Christina Stacey - RE: Permit #2923 - 1125 Brighton Ave (Loring House)

Thank you for the additional information. The proposed changes for the Loring House do not trigger site plan review. All of the work can be handled through the building permit process.

Wright-Ryan has been hired by Wishrock to be the CM at Risk for a renovation project at 1125 Brighton Ave. We have submitted for a Building Permit - #2923. I have copied Penn Lindsay – VP at Wishrock - and Phil Renzi – the Architect on this email so that they can participate in this conversation.

**ARCHITECTURAL
SITE PLAN**

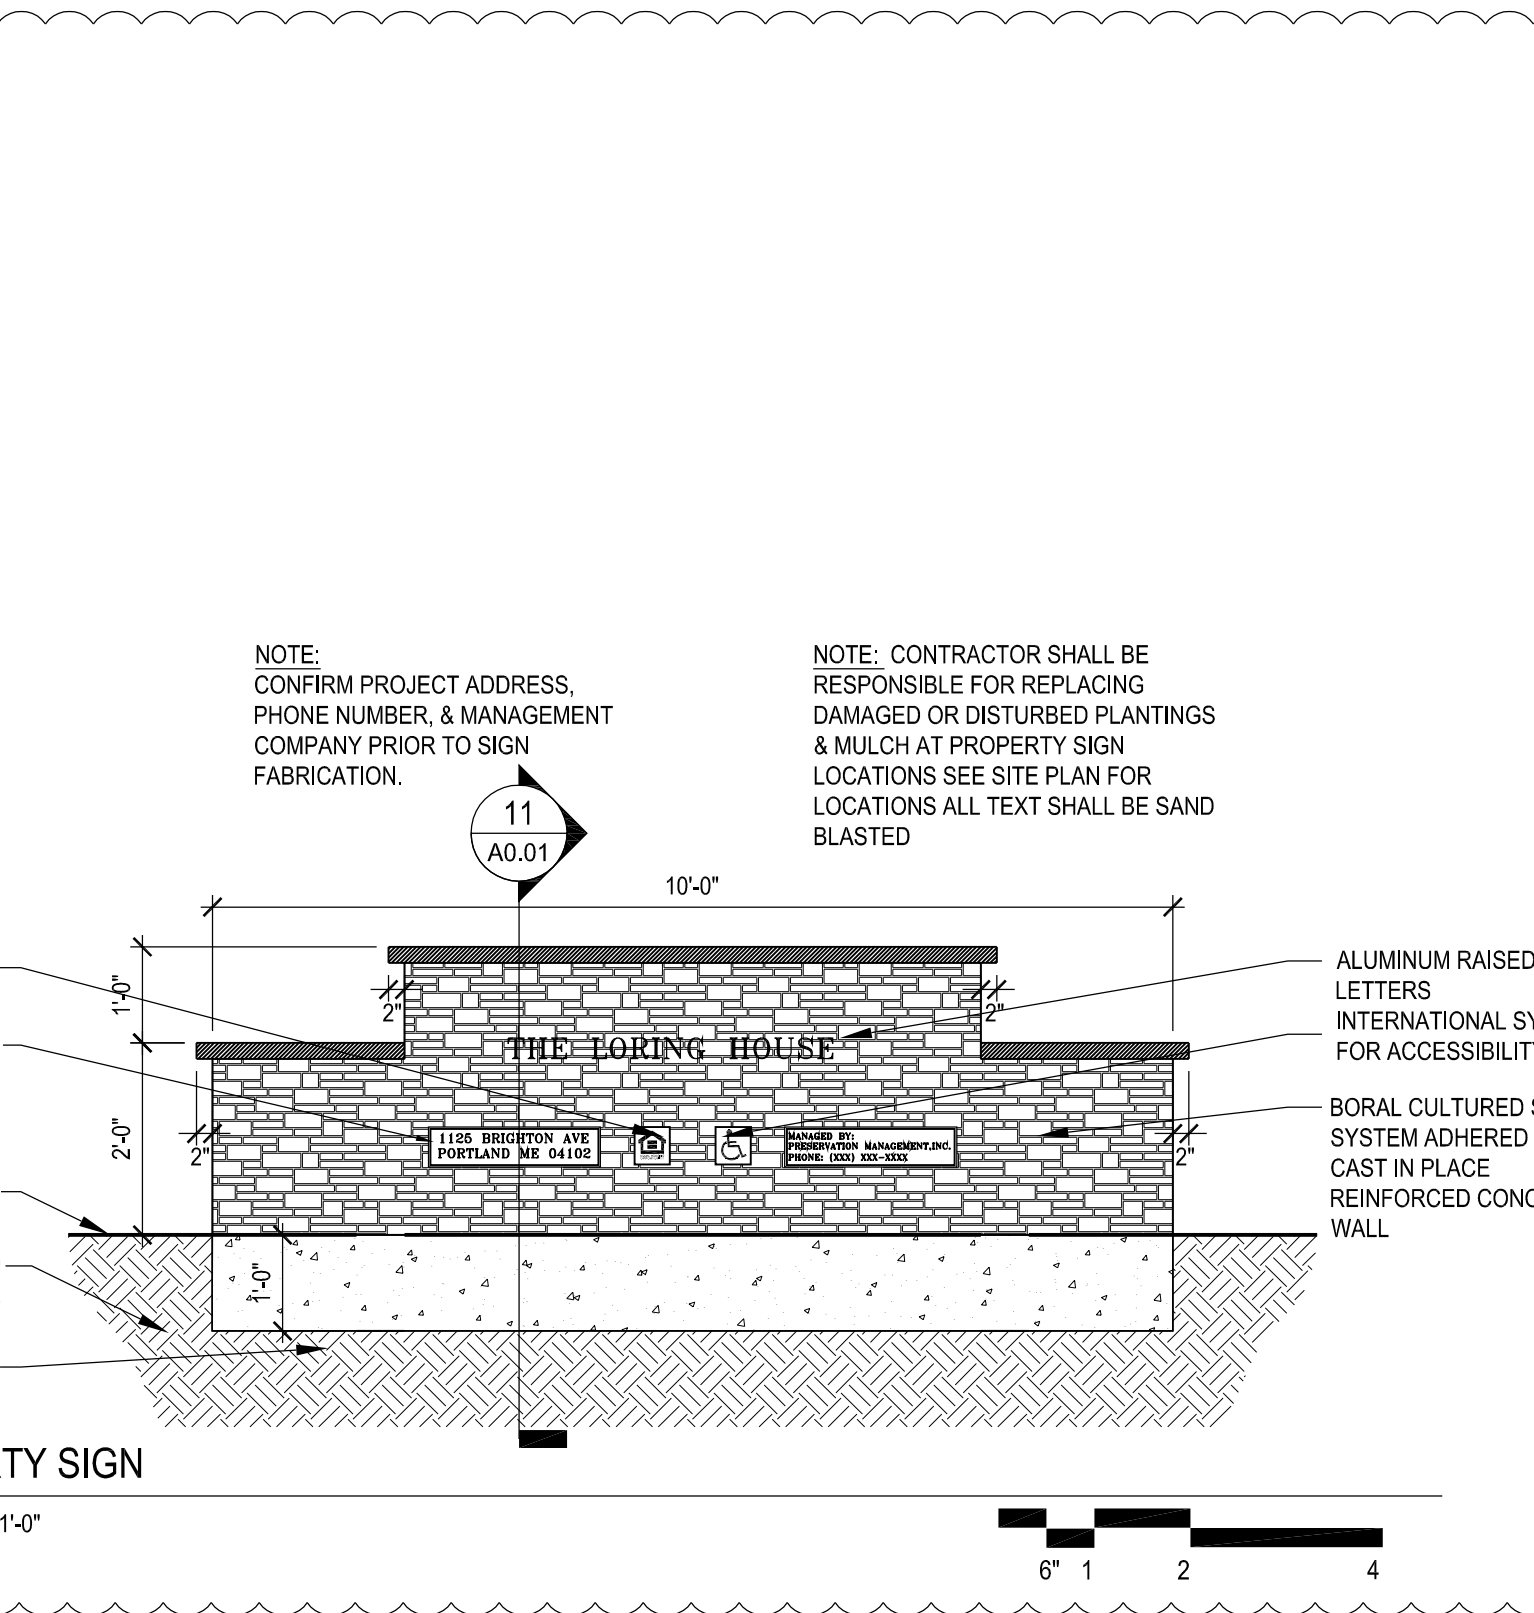
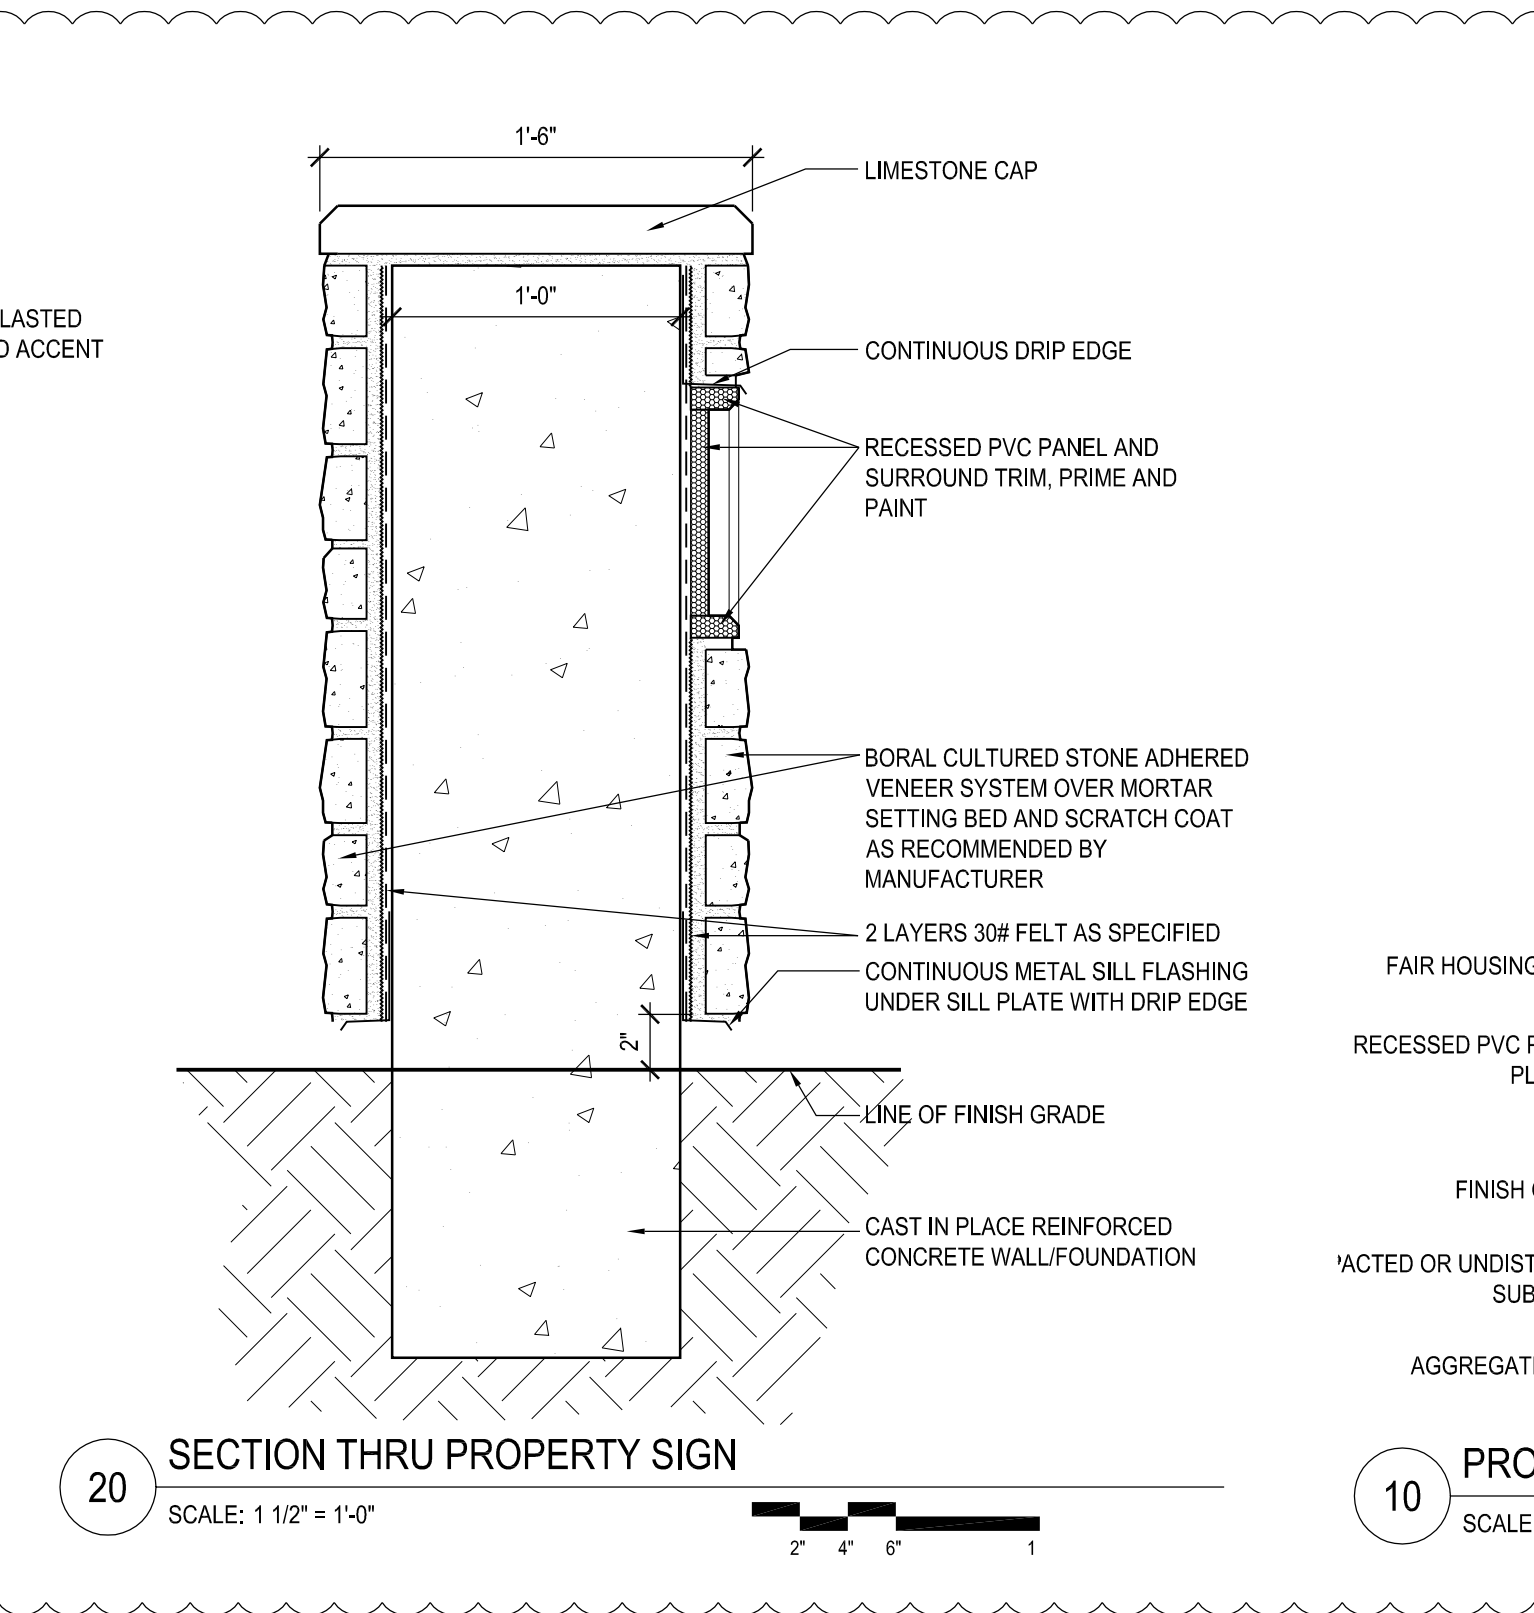
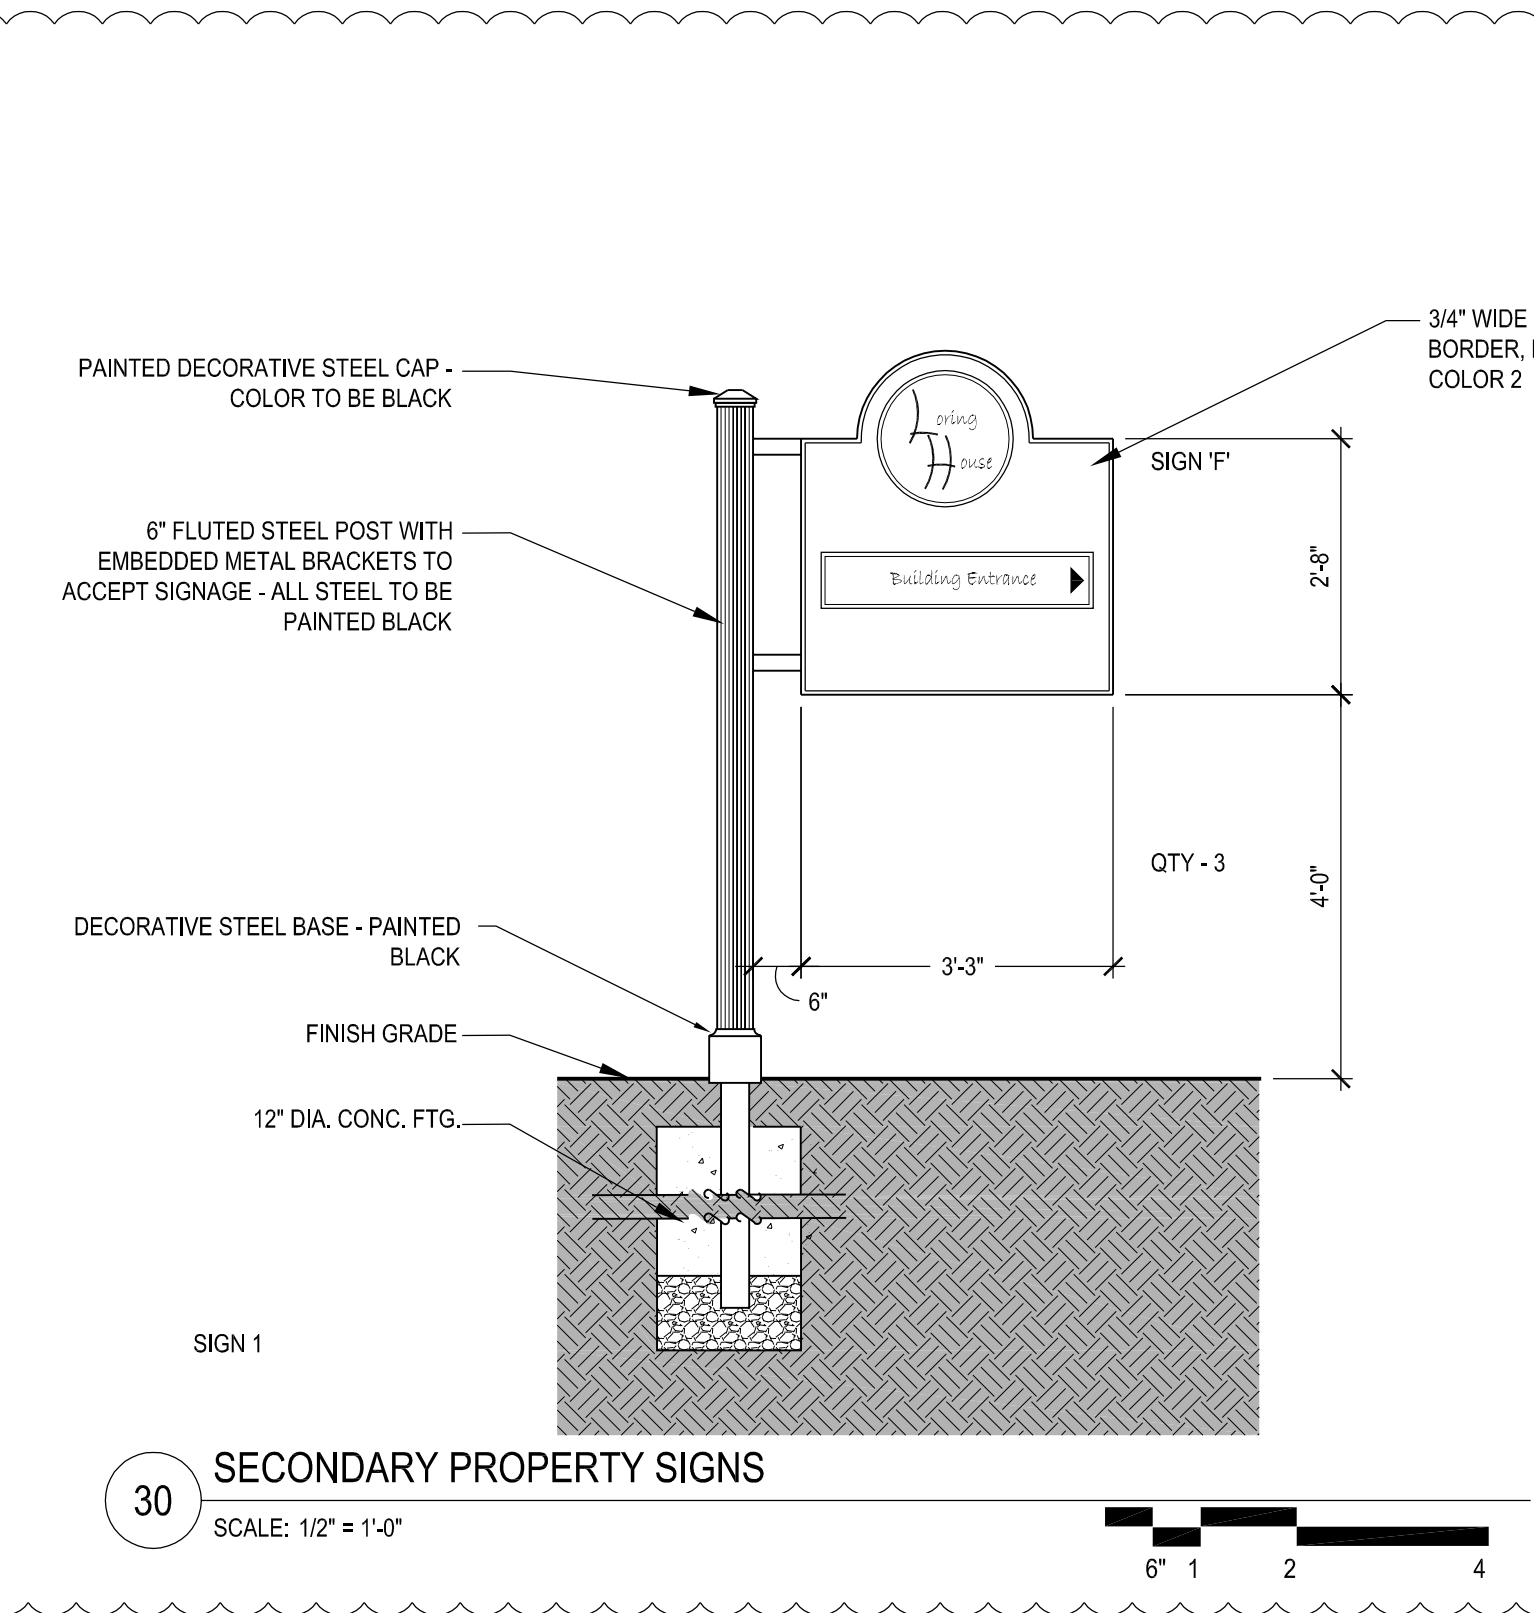
There is a note that the areas will be graded to pitch away from the buildings. Do you have the proposed grades that can be layered over the existing grades?

Hi Barbara: The note is really meant to ensure that positive drainage away from the facades is maintained, or where needed, provided, we are not planning on changing the grades. Given the small elevational difference between the invert of the catch basin inlets and the sills of the existing windows we cannot re-grade.
